Report to Wollstonecraft Precinct St Leonards Crows Nest Final 2036 Plan and Crows Nest Over Station Development (SSD-9579)

Purpose: The purpose of this report is to provide:

Part B: Crows Nest Over Station Development (SSD-9579)

General Arrangement Sections and Elevations

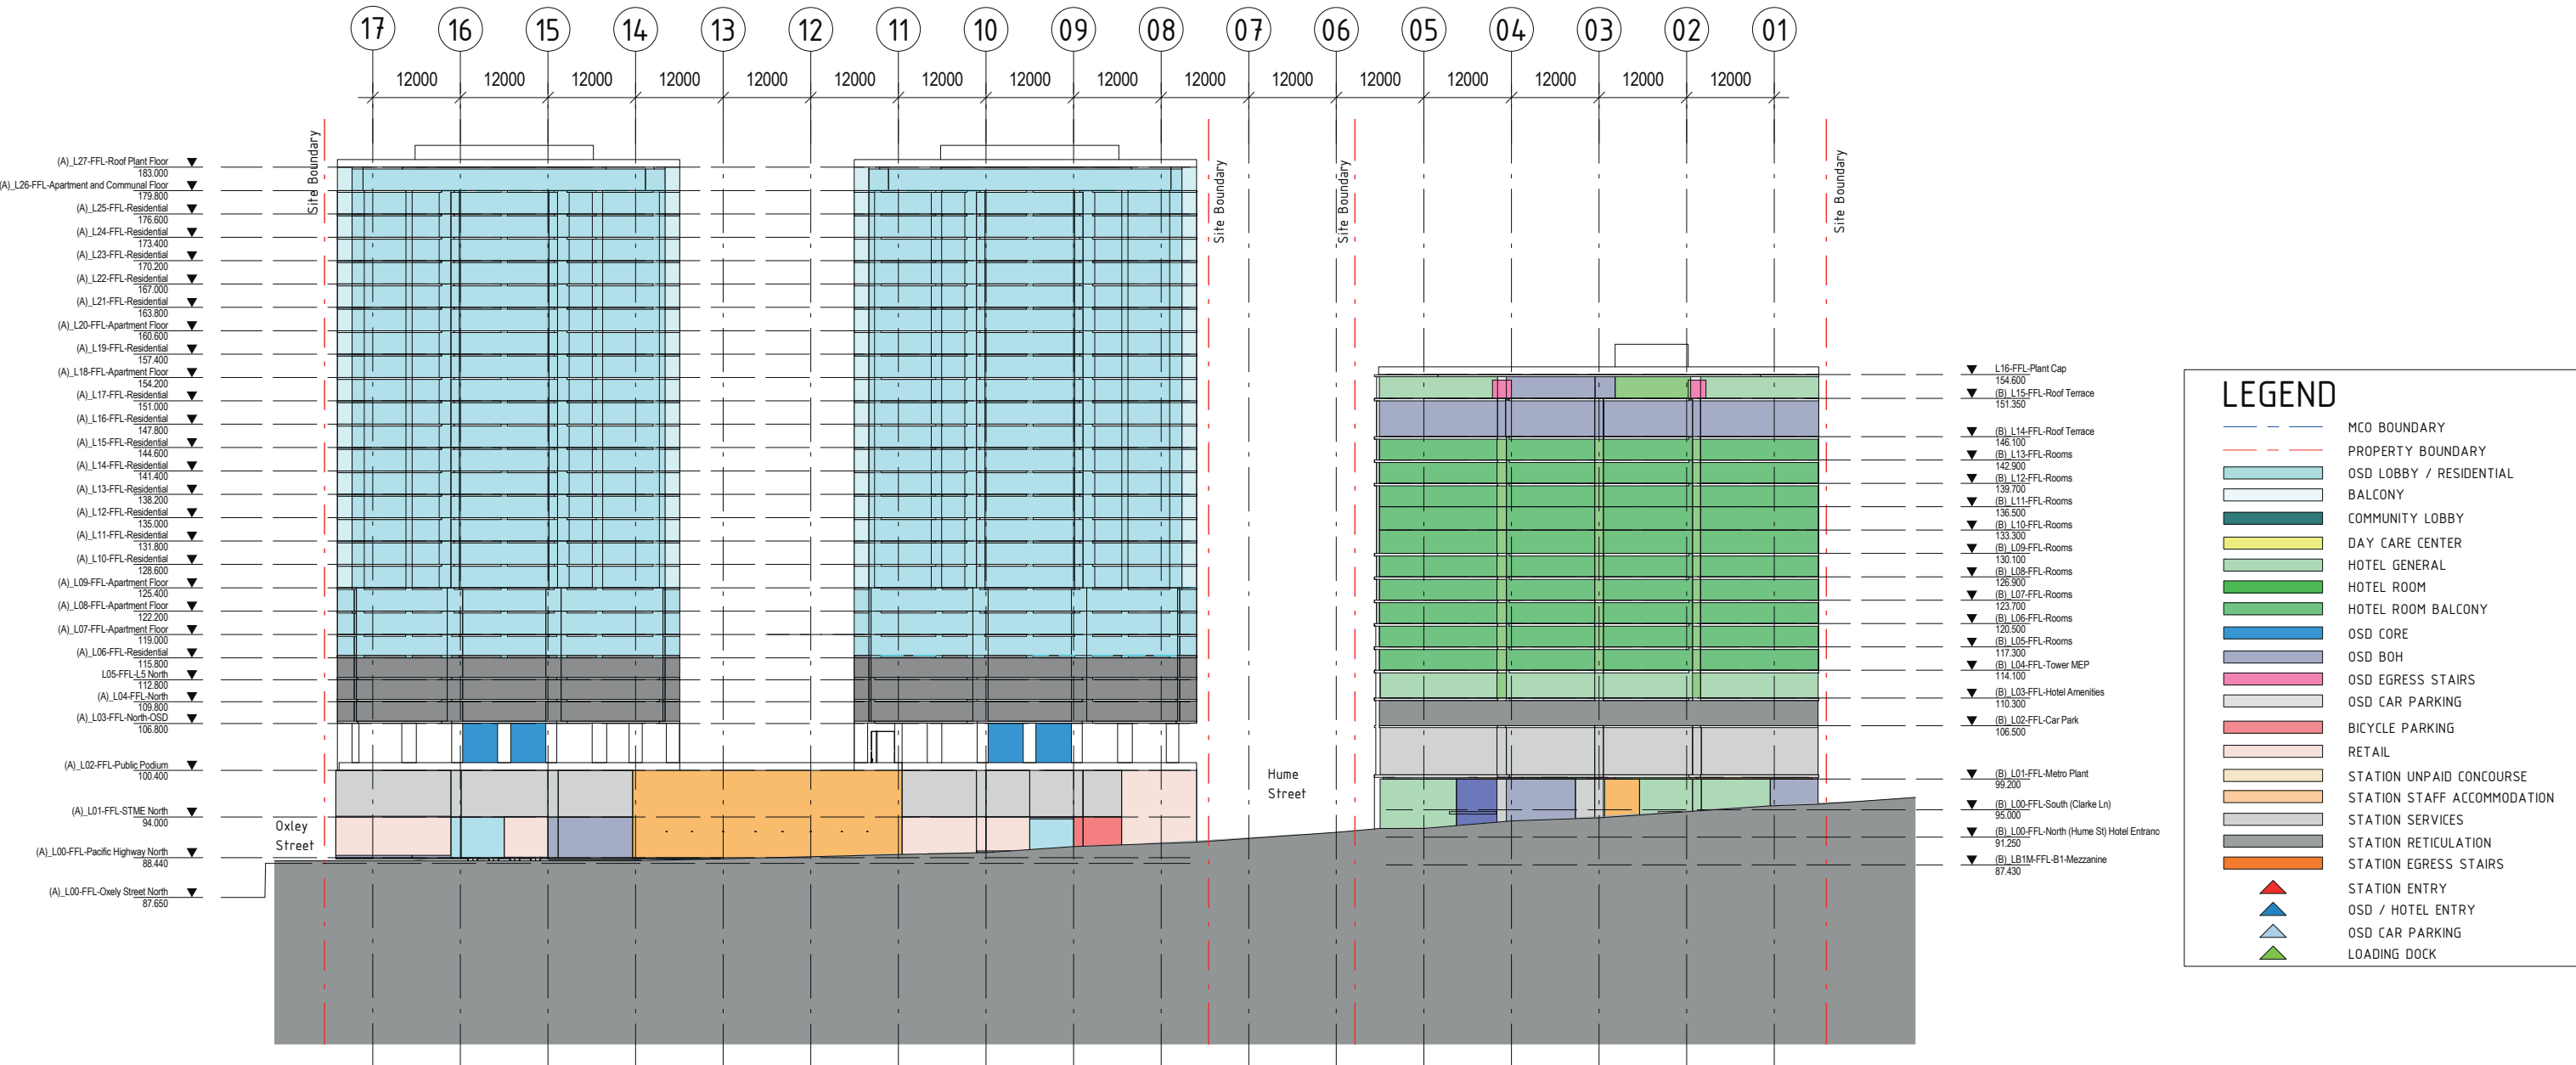
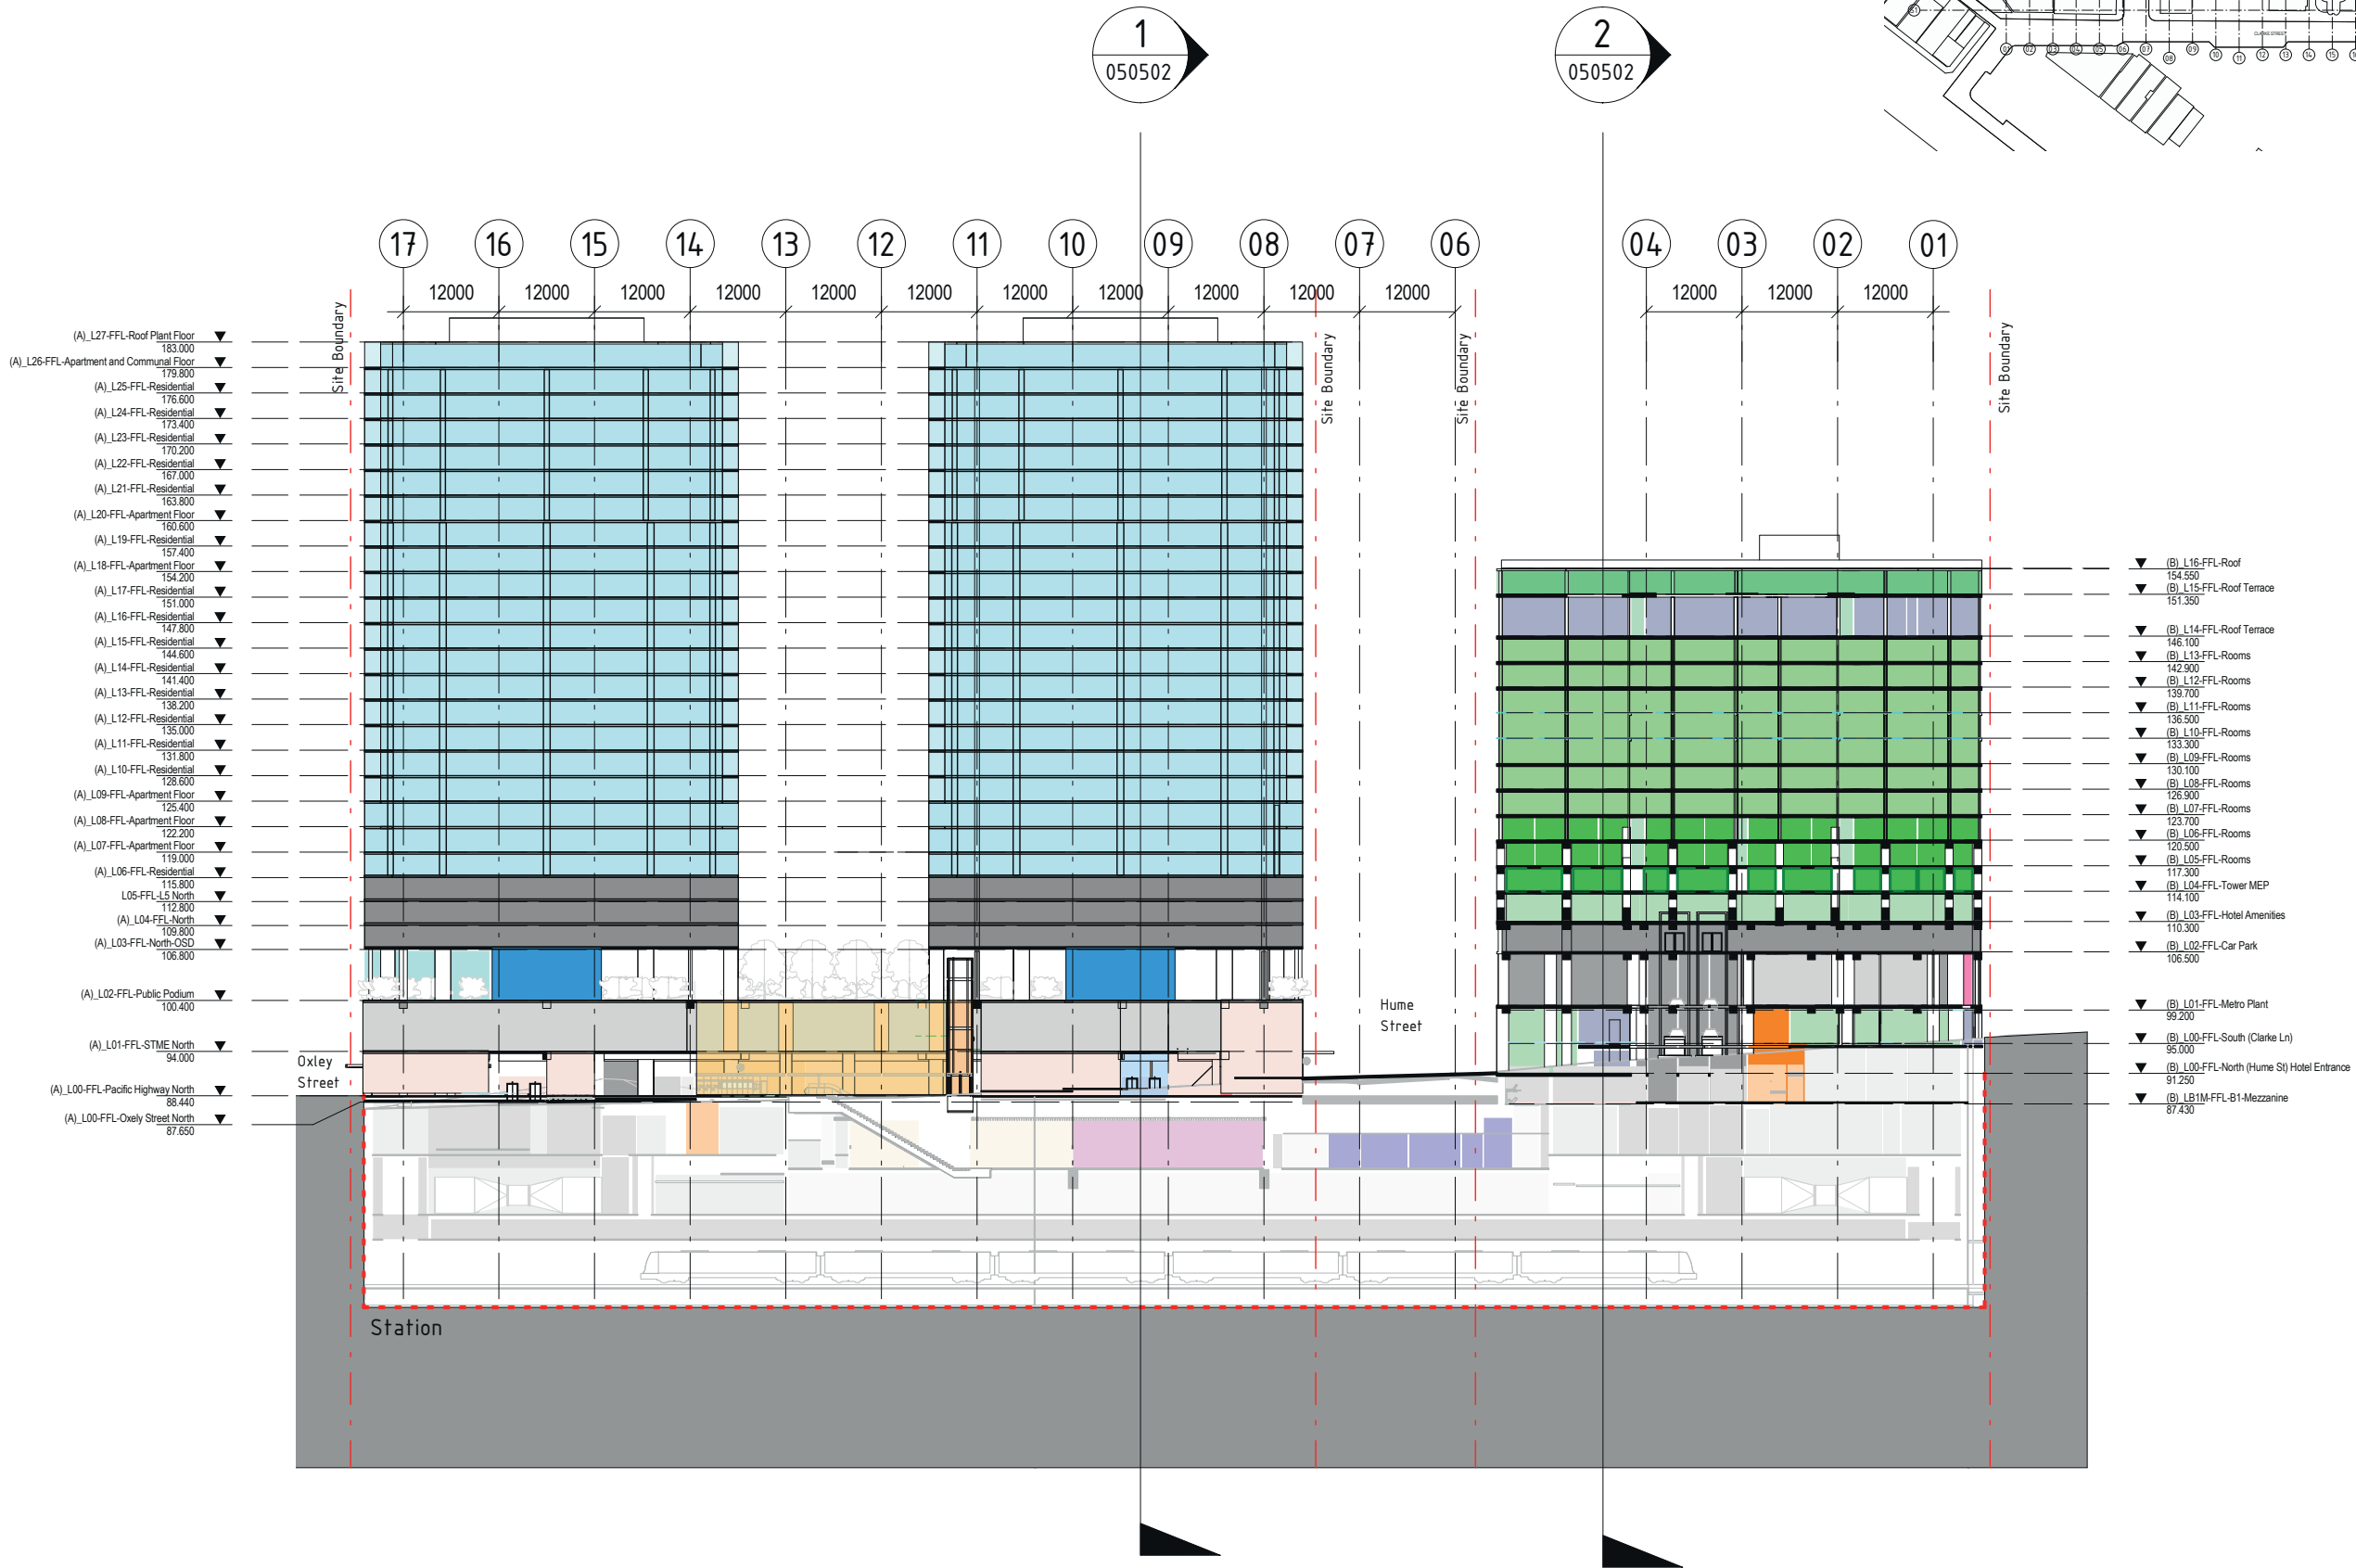
The community argued that this approach by Sydney Metro was flawed when they proposed heights up to 27 storeys over the metro station and 18 storeys on the opposite side of the highway. In the end what we got was a meagre reduction in height of 7.4 metres (2+storeys) for the building on Site A, offset by an increase of 6 storeys for the buildings on the block on the opposite side of the highway. The community was unanimous about this argument and asked for significant height and scale reductions to both sites but the DPIE sided with the consultant and Sydney Metro. They did not listen and have breached our trust on these two sites. It is a serious error and totally unnecessary.
